Written submission for Deadline 4, 13/01/2021

Richard Reeves, AP EA1N AFP 133 / IP 2002765

Responses, Questions, Corrections

RE The Applicants' Landfall Hydrogeological Risk Assessment 24/02/2021

| Important Hedgerows and Tree Preservation Order Plan Sheet Number: Sheet 2 of 12 | | | Rev | 5 | British National Grid OSGB36 |

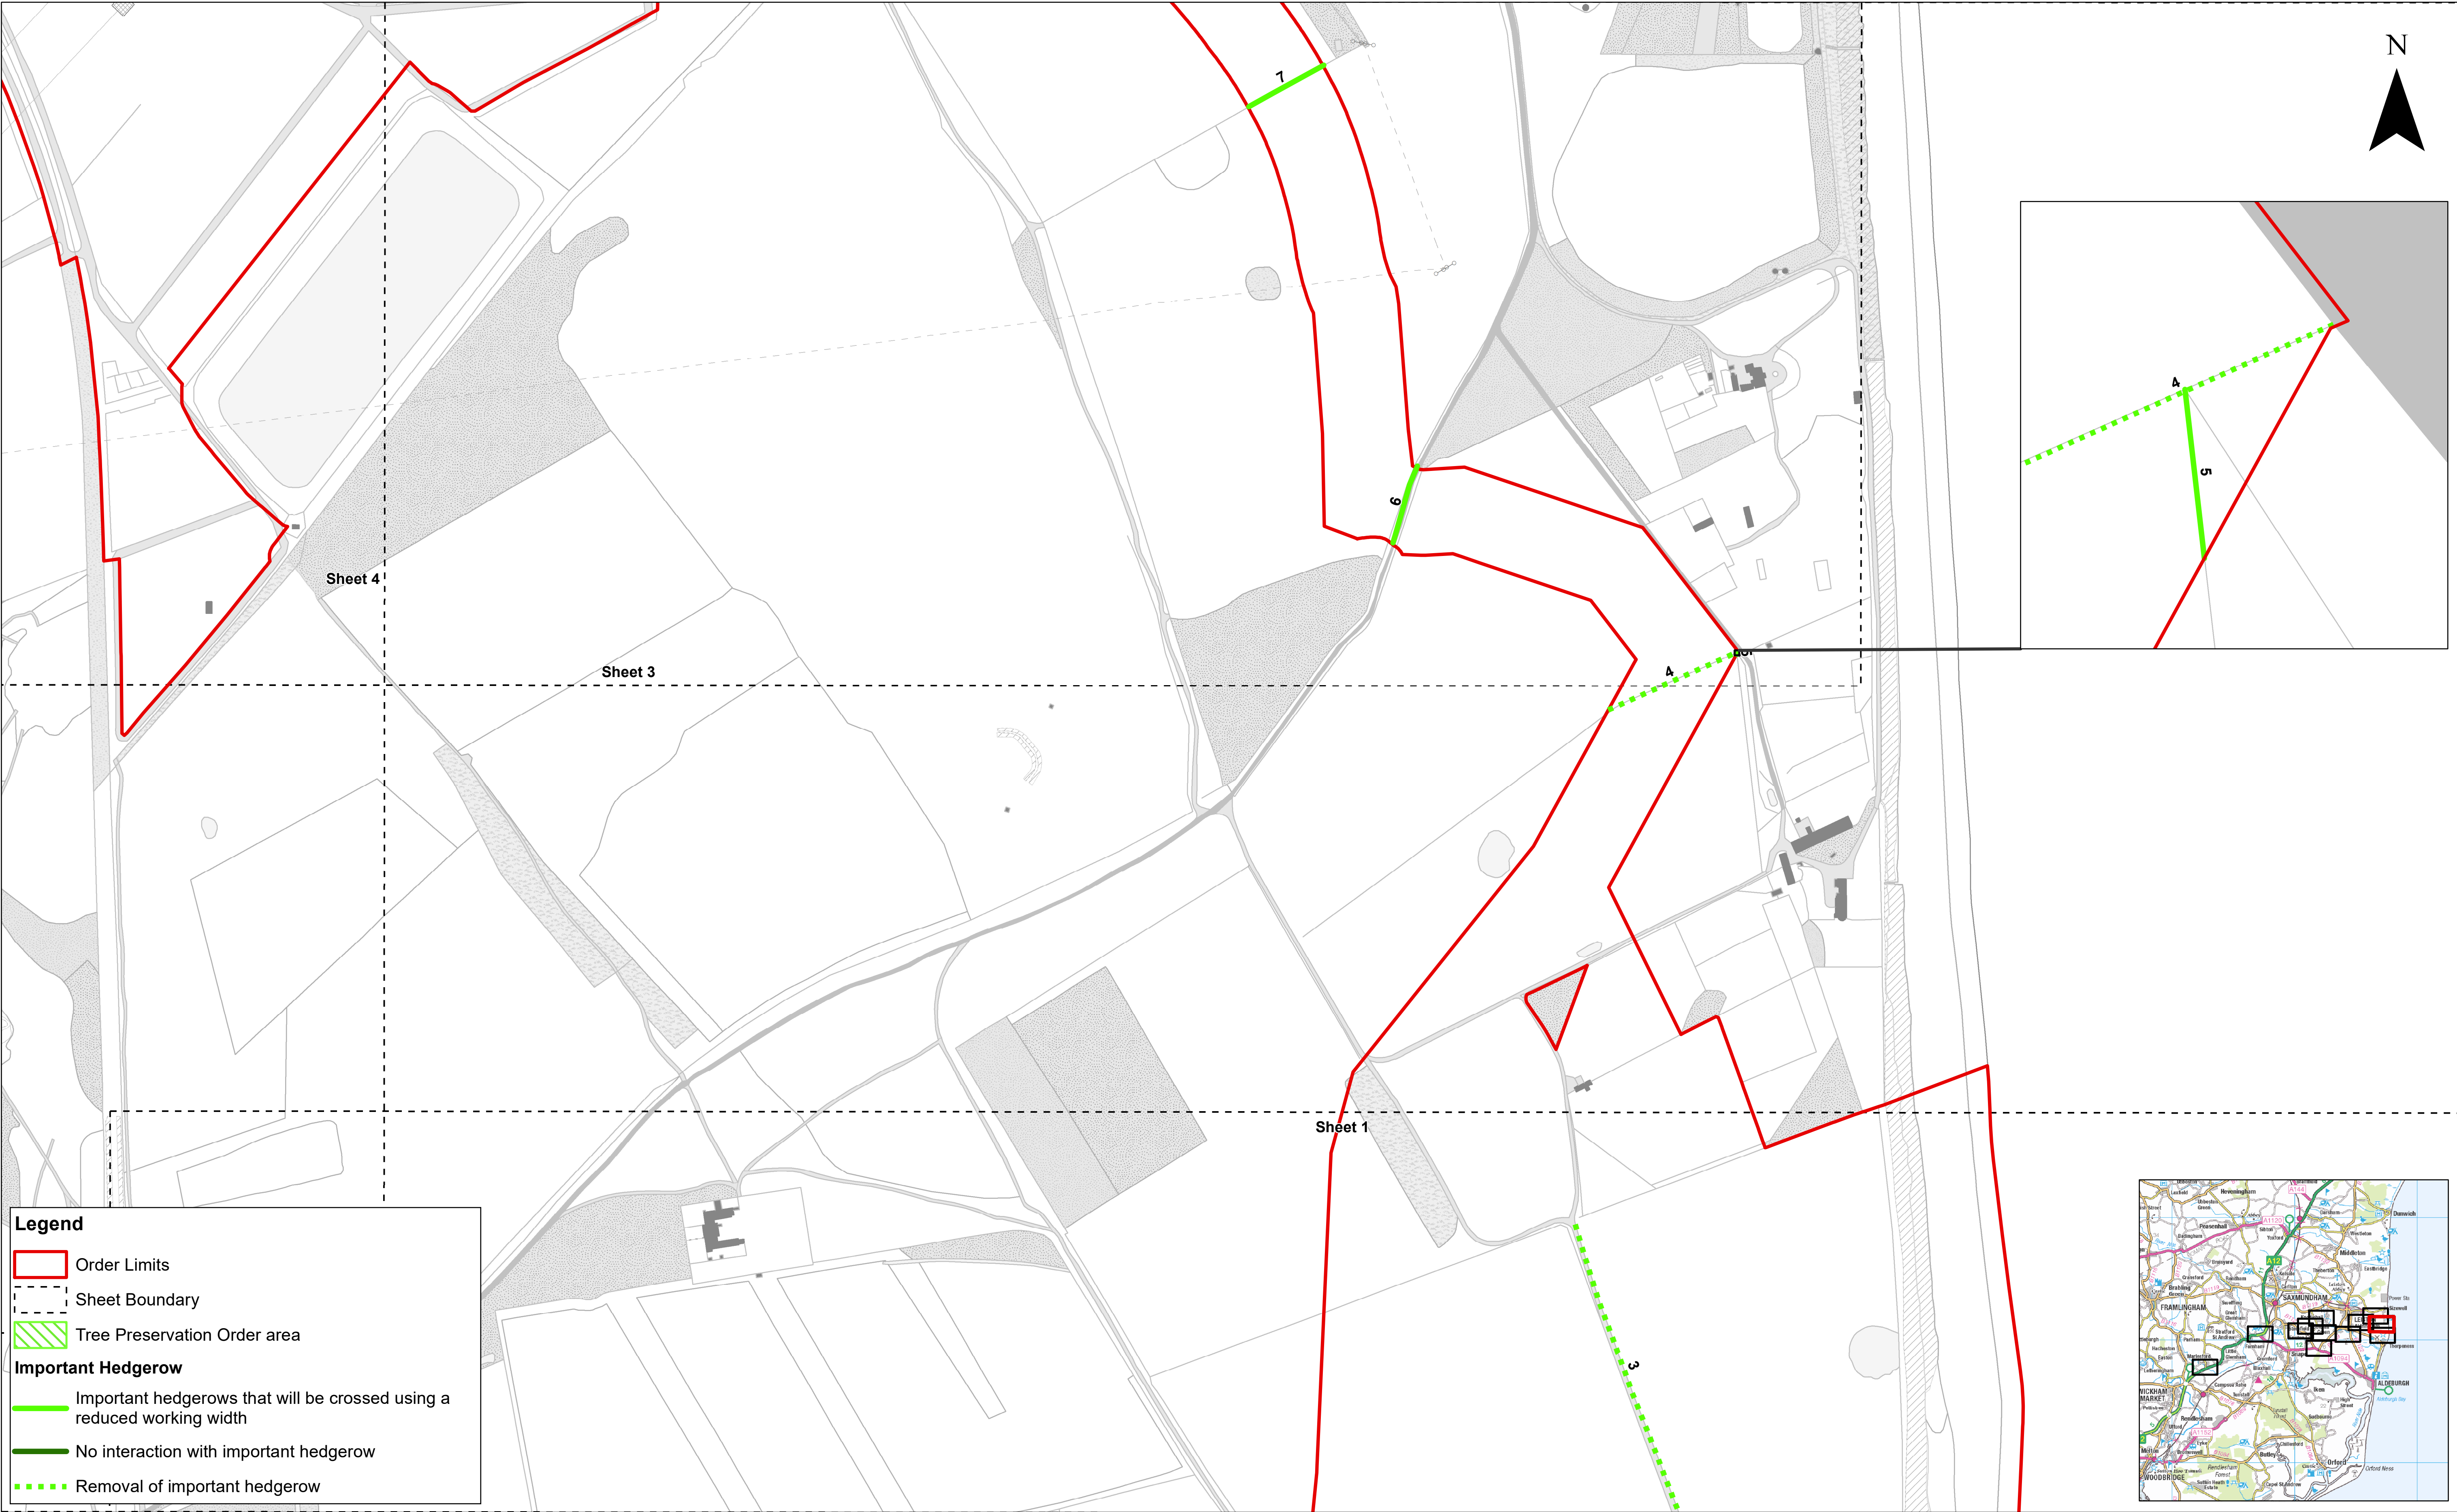
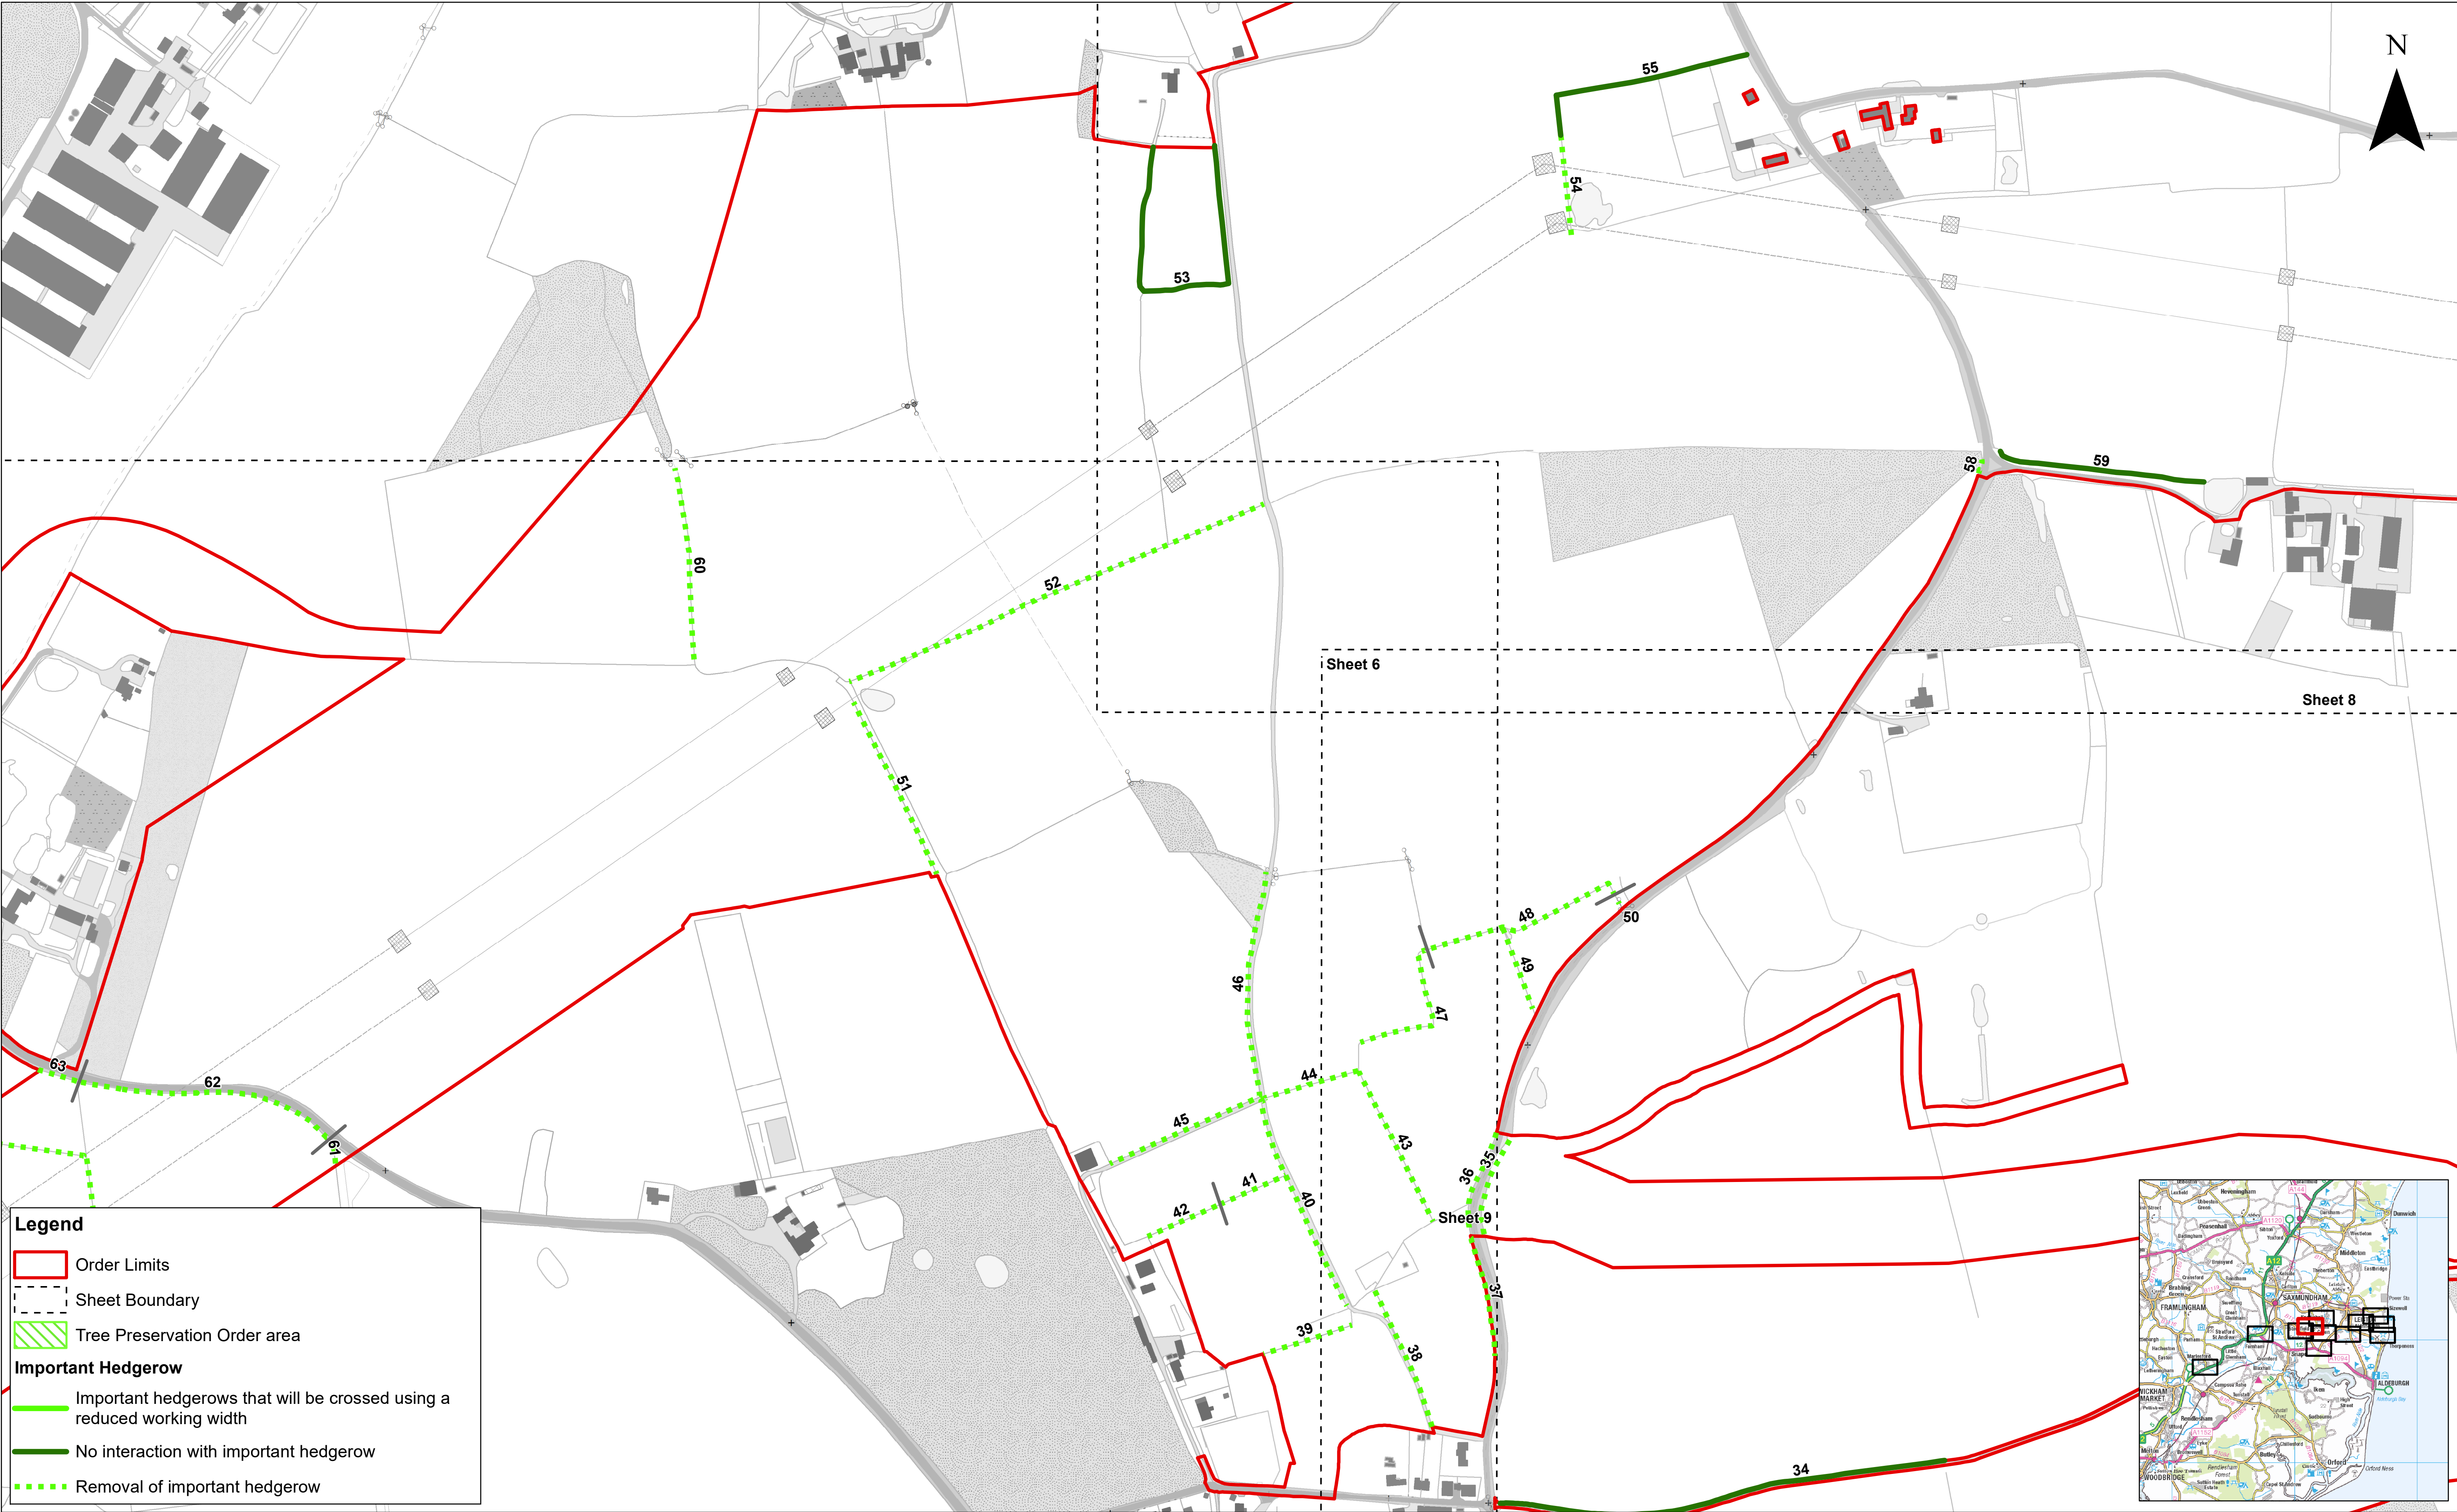
In Important Hedgerows 3 and 4 (scheduled for demolition) and the associated hedgerows linking and bordering plots 10;12;13;14 more than 40 species of wild flower have been recorded (cf my earlier submissions which include species recorded by Wardens volunteers and trustees over several decades). Amongst these flora are Red Valerian; Honeysuckle; Petunia; Sloe; Hawthorn; and numerous nectar-rich flowers. The species I name here are of particular relevance to several rare and protected species; three examples: the Hummingbird Hawk Moth; Lampyris Noctiluca (the Glowworm); Elephant Hawk Moth.
